REVIEW RESPONSE

DATE: 01-26-2022
PROJECT NAME: SHL20-044 & SEP-20-023_SUN
RESPONSE TO:
CITY OF MERCER ISLAND – PLANNING DEPARTMENT
9611 SE 36TH STREET
MERCER ISLAND, WA 98040-3732

This letter is in response to the corrections for SHL20-044 and SEP20-023 Shoreline substantial permit. Below are our responses to the questions/comments from January 13th, 2022.

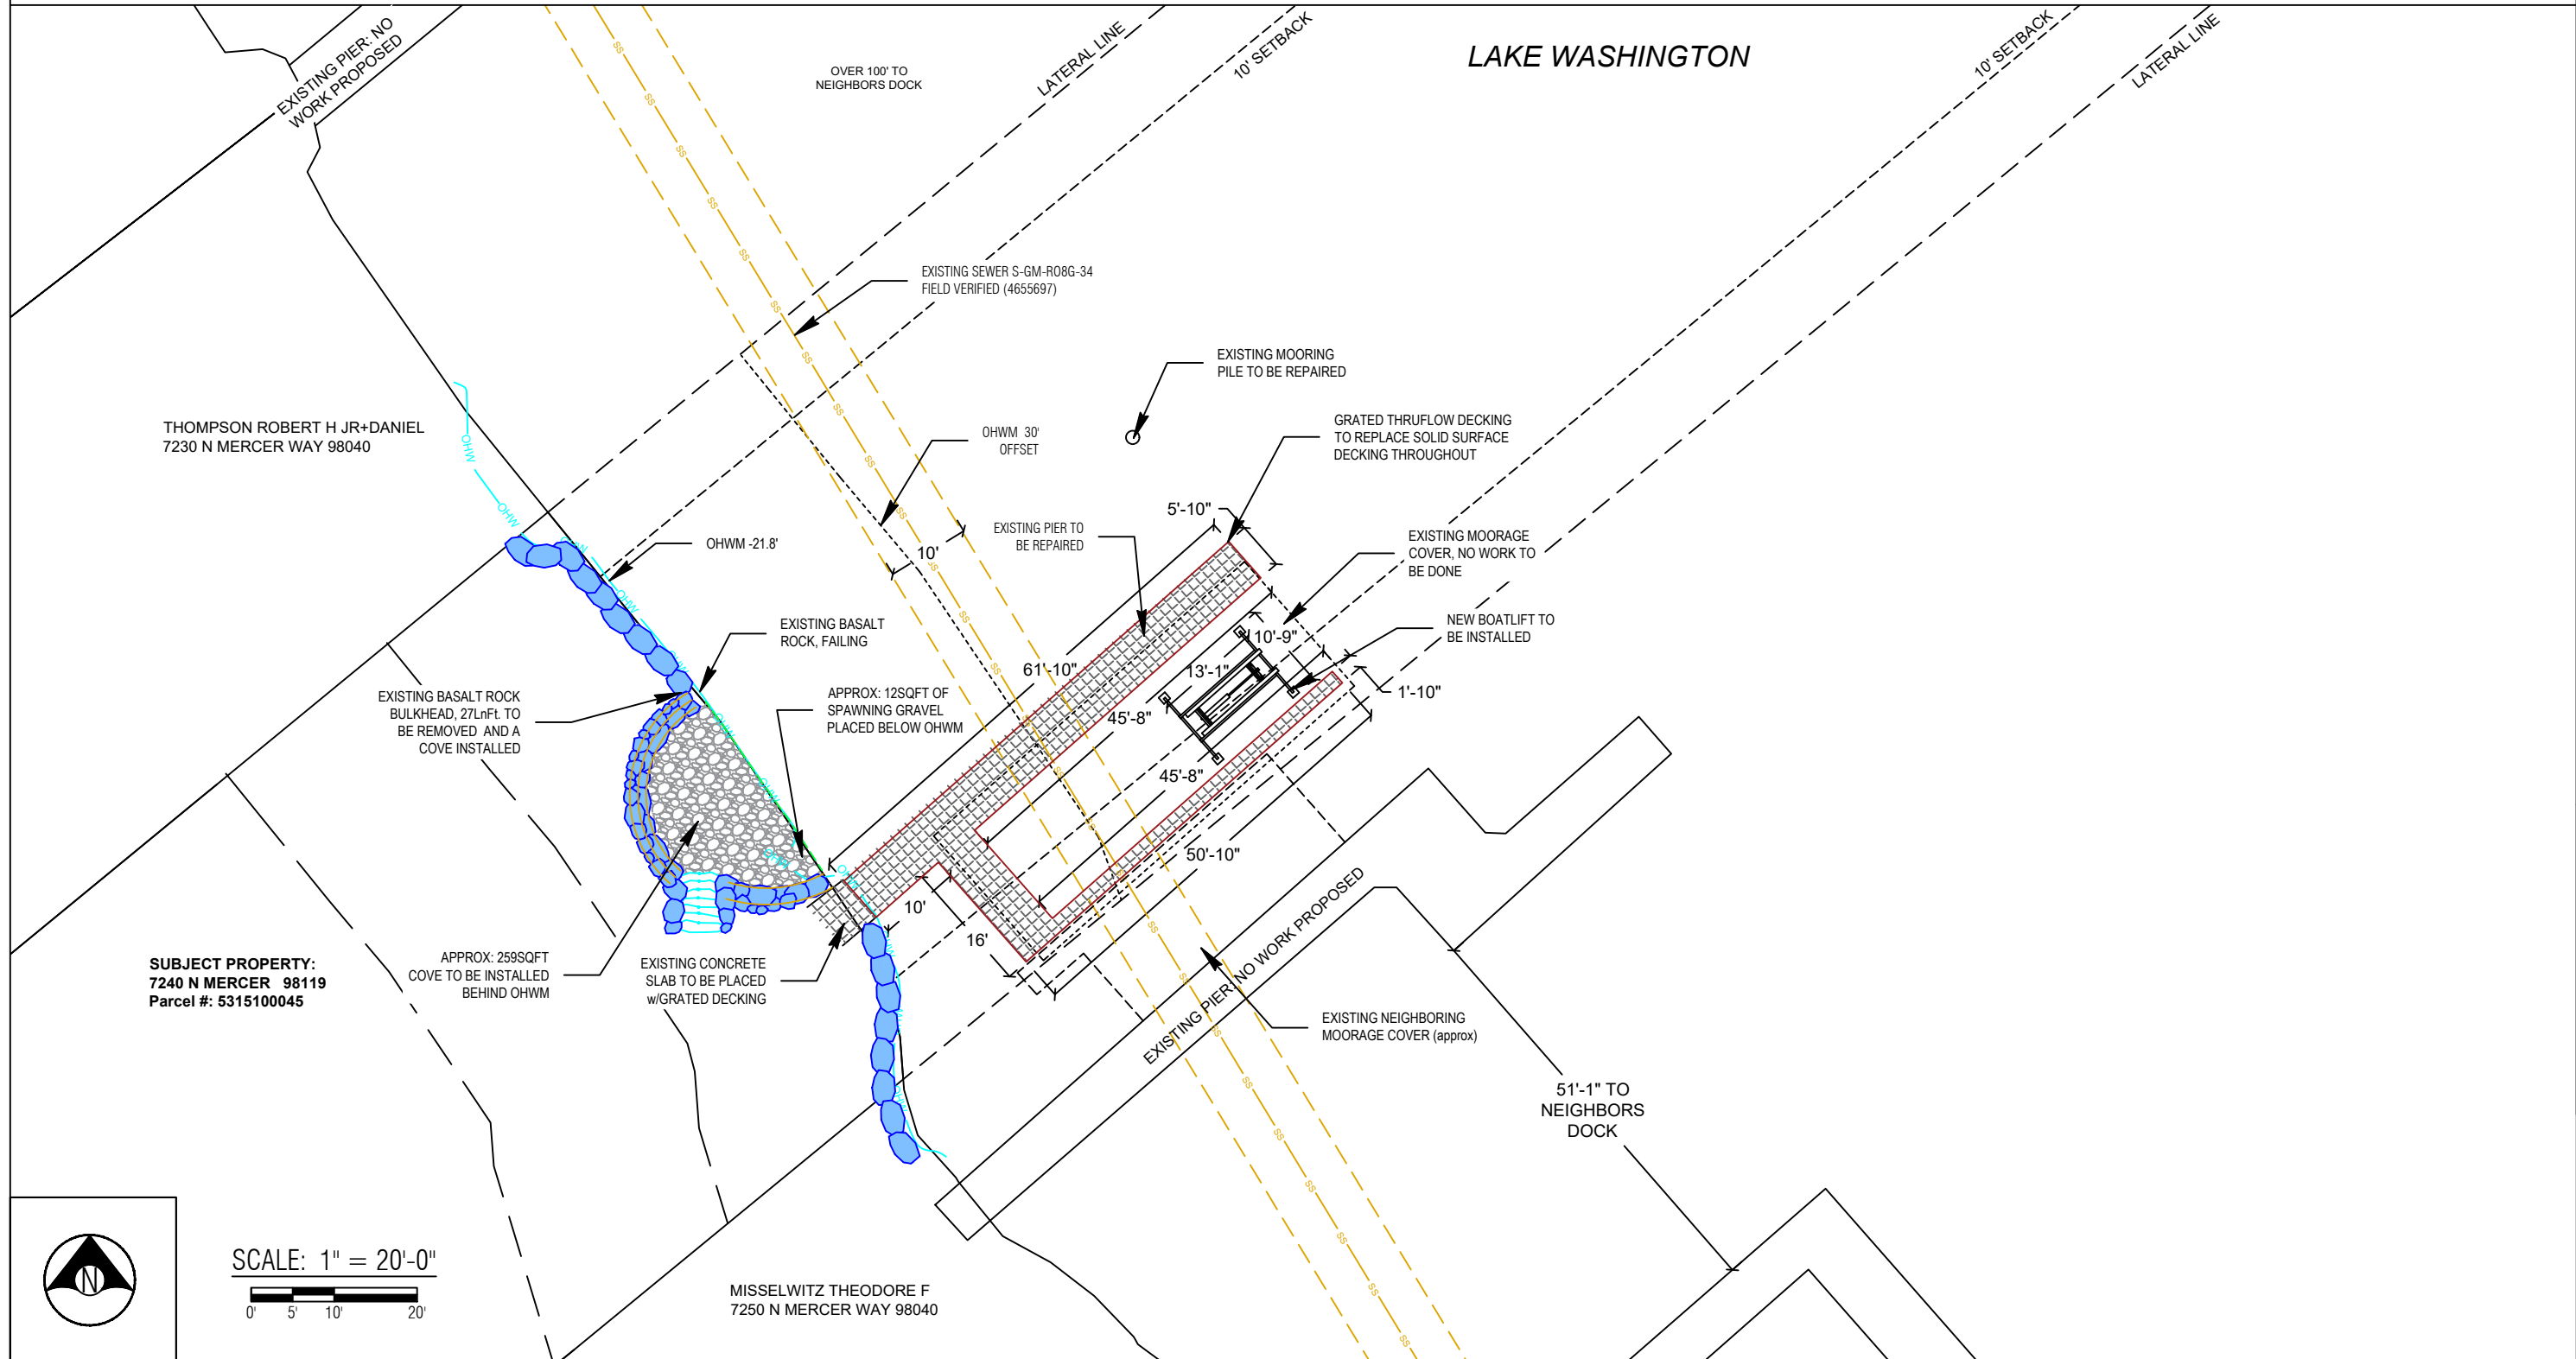
- a. Sheet A3.0 states that the ~189sf gravel cove will be installed behind the OHWM. However, there is a portion of the gravel that is proposed waterward of the OHWM that is highlighted in the snippet below. Revise to state the amount that is below OHWM and state the type of gravel used (i.e. spawning gravel, angular rock, etc.)

Plan set has been updated to show “12sqft of spawning gravel placed below OHWM” on sheet A3.0. I have also updated the cove to be 259sqft of spawning gravel behind OHWM.
